Section 73 Application
Land Adjoining and West of Stonecroft House, Clifton Road, Deddington
Erection of 7 one and two storey age restricted dwellings for older people (60+ years),
formation of means of access, and associated landscaping and infrastructure

We have been instructed by Blue Cedar Homes Limited (the applicant) to submit a Section 73 application to vary Condition 2 (approved plans and documents) attached to planning permission no. 20/03467/F for the above development.

Proposed Entrance Gate and Planter

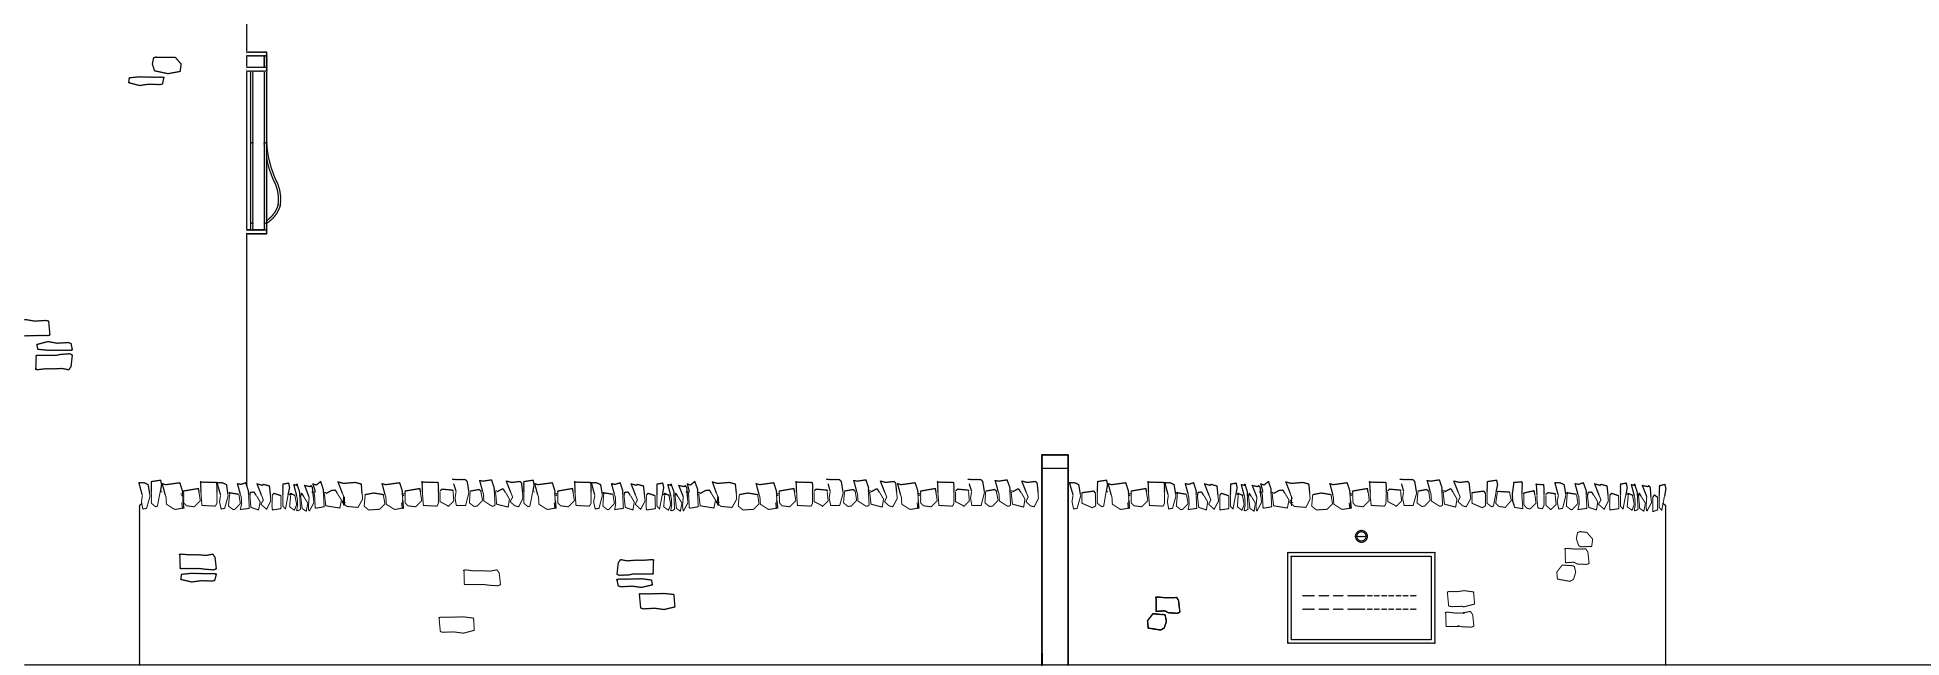
Entrance Wall

Managers store incorporated.

Plots 1 & 2
 Ground Floor Plan

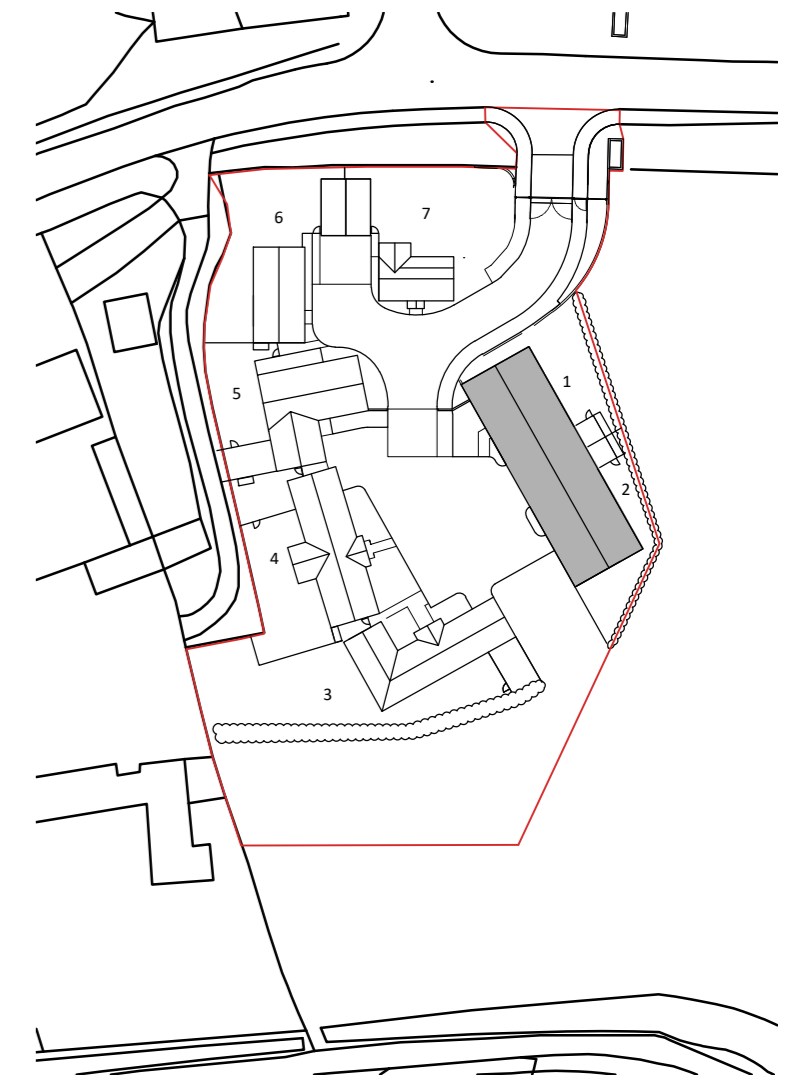
Plot 1

Slot windows to front elevation removed and large window added to bedroom 2 Rooflights removed.

Internal changes to comply with M4(2) and improved useability generally

Plot 2

Window added to kitchen

Internal changes to comply with M4(2) and improved useability generally

The Poplars, Land South of Clifton Road  
 Deddington  
 Plots 1 & 2  
 Proposed Elevation

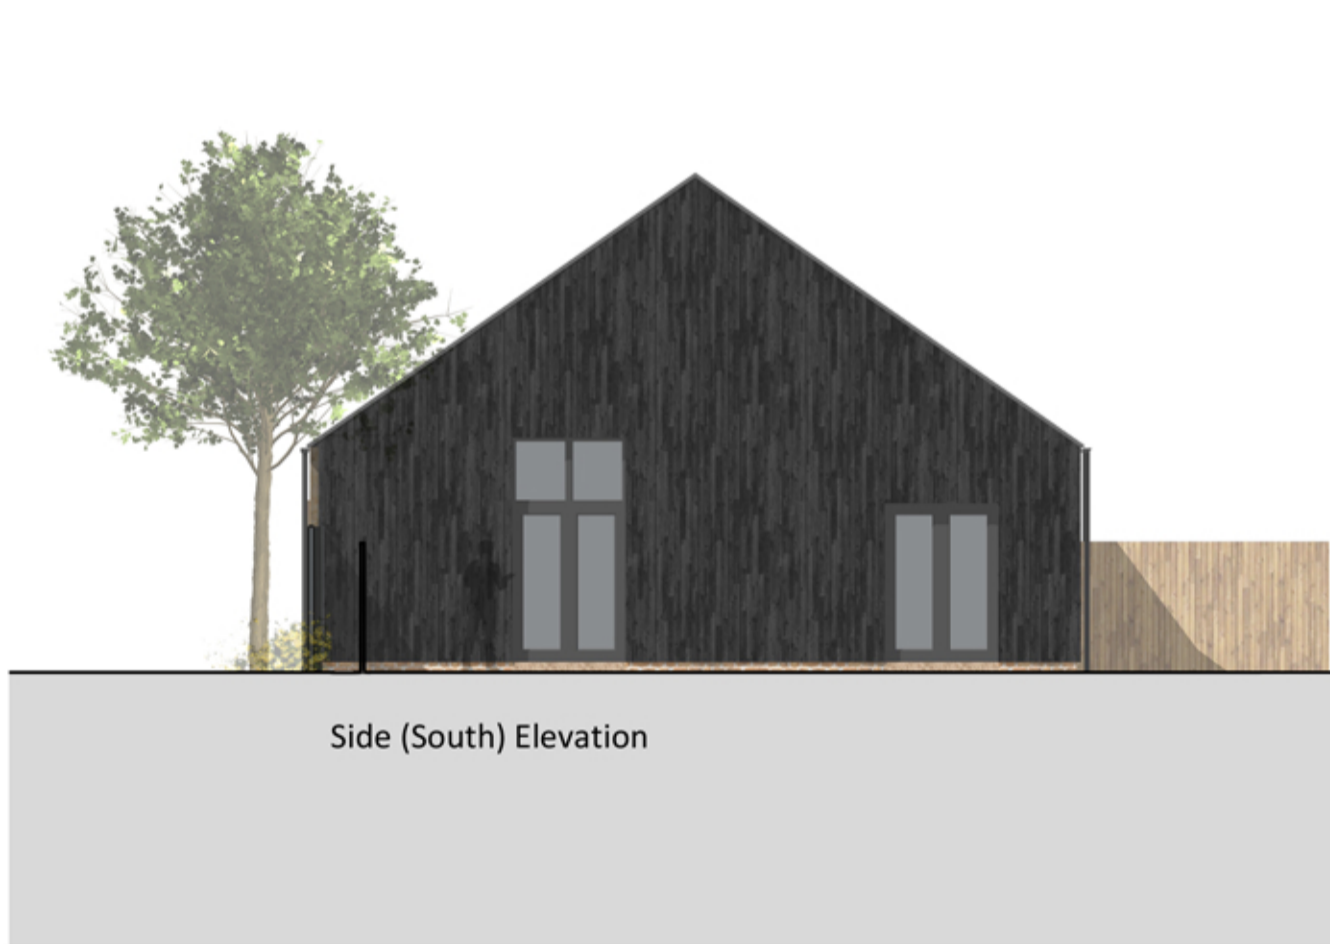
Plot 1 and 2

Cat-slide roof to rear replaced by single pitched roof over entire width of plot and main roof pitch reduced Ridge height maintained Car port roof lowered

Plot 6
Plans

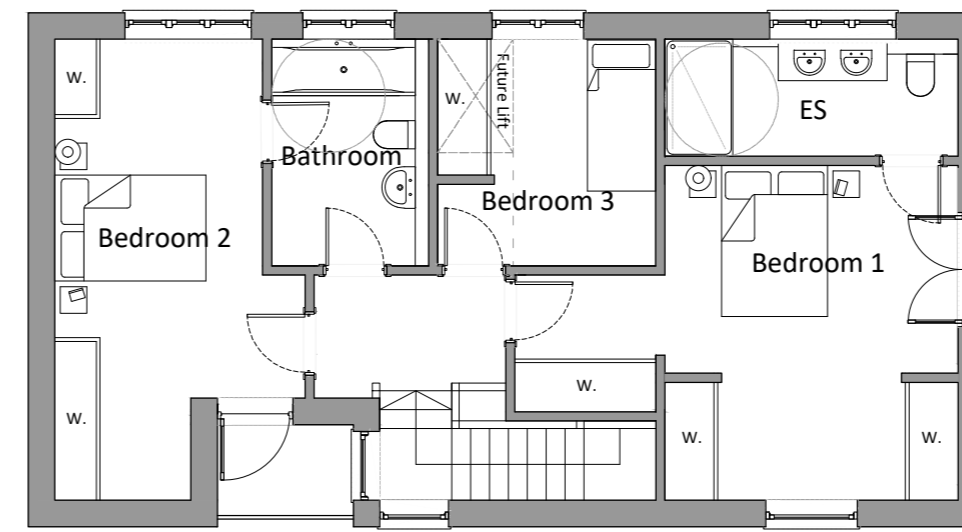
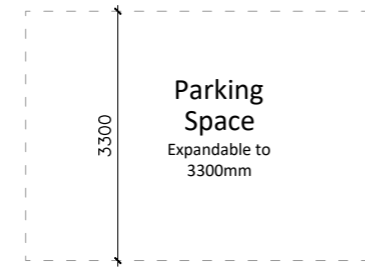
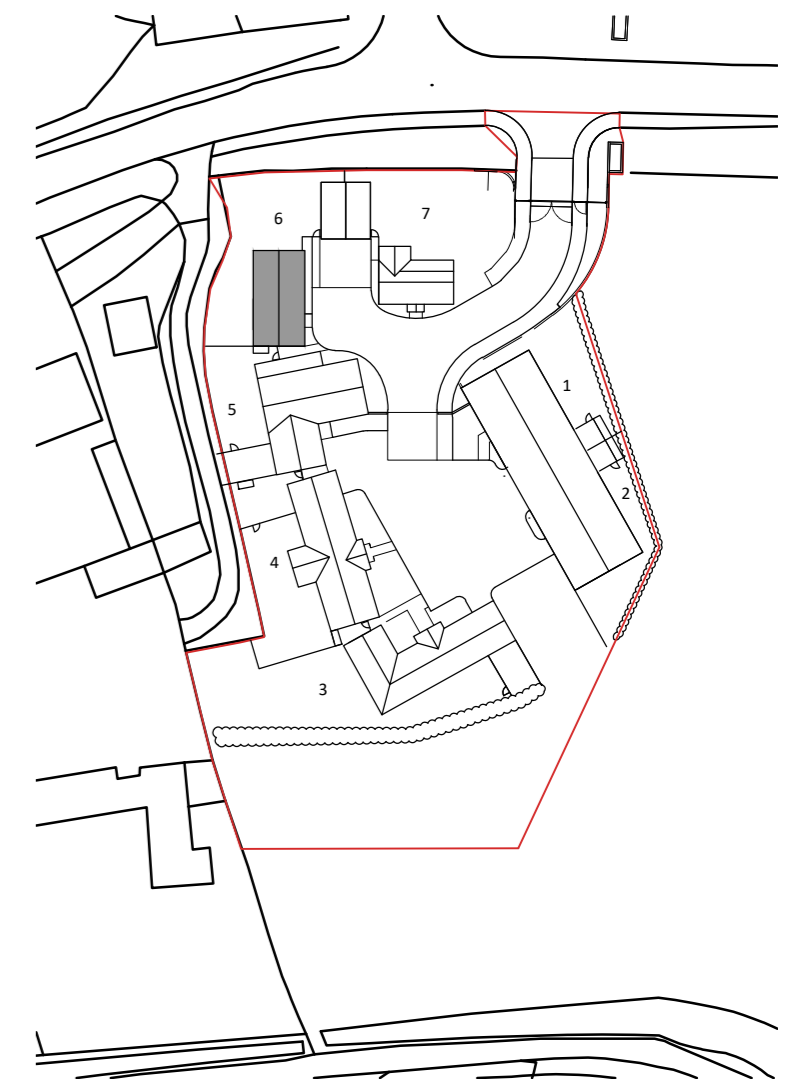
Plot 6

Black timber panels added to front and rear elevations Windows widened to front and rear elevations and reduced to north.

Internal changes to comply with M4(2) and improved useability generally
